Application by Light Valley Solar Limited for an order granting development consent for the proposed Light Valley Solar project.

Issue Specific Hearing 1 (ISH1) – Action points and Errata and clarifications

Date: Thursday 30 July 2026

Drawing Number
EN110012/APP/LVS/06.02.02.06.03

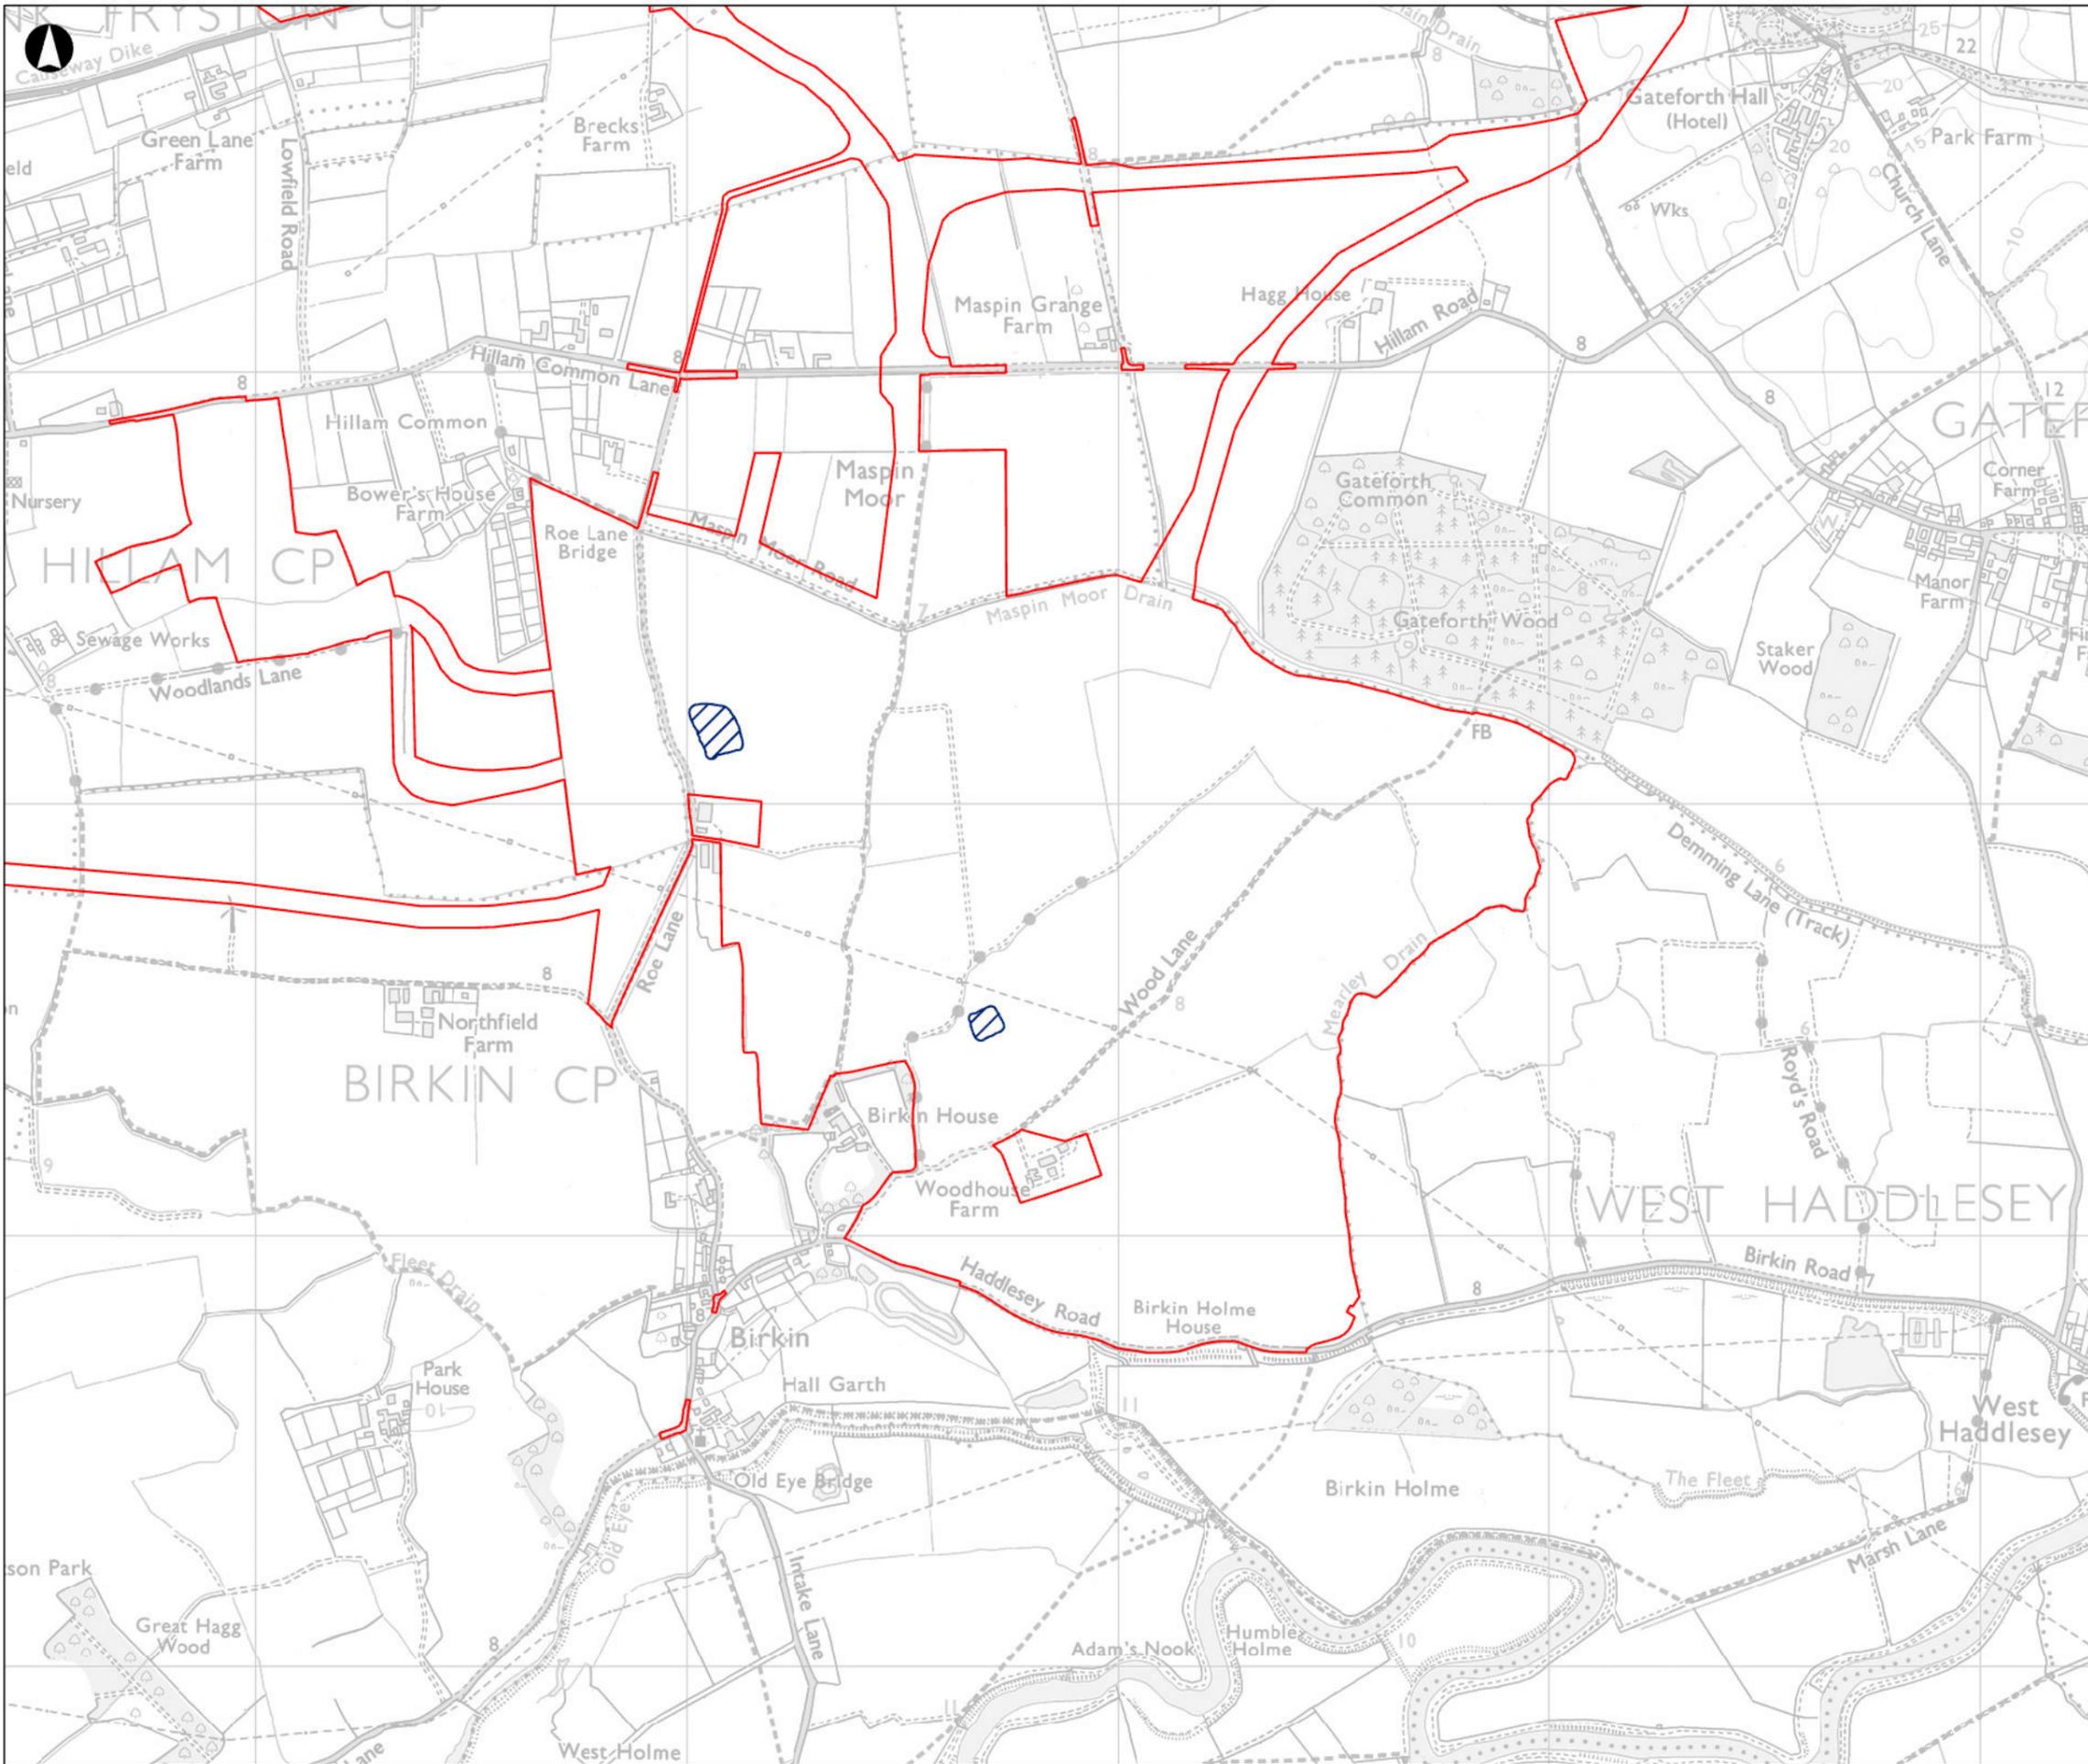
[APP-046]	ES chapter 8 and Figures 2.5 and 2.6	Paragraphs 8.8.3 and 8.8.5 of ES chapter 8 [APP-046] refer to the concrete feet locations or other non-ground penetrative techniques being shown on Figure 2.5 however this shows the Avoidance Areas [APP-062]. Is this reference correct, should it be Figure 2.6 instead which is entitled Solar Panels Concrete Feet or Other Non-Ground Penetrative Techniques [APP-063]. Please check and amend any references accordingly (this includes other documents and chapters).
[APP-190]	Non-technical summary, para 7.2.17	Paragraph 7.2.17 of the non-technical summary [APP-190] states that there is 495ha of best and most versatile agricultural land within proposed development and that approximately 17.5ha would be required for the permanent elements involving soil sealing. These figures differ to those cited elsewhere within the ES (i.e. paragraph 5.9.19 of ES chapter 5 [APP-043]) which states figures of 486ha of land and 19.1ha respectively.
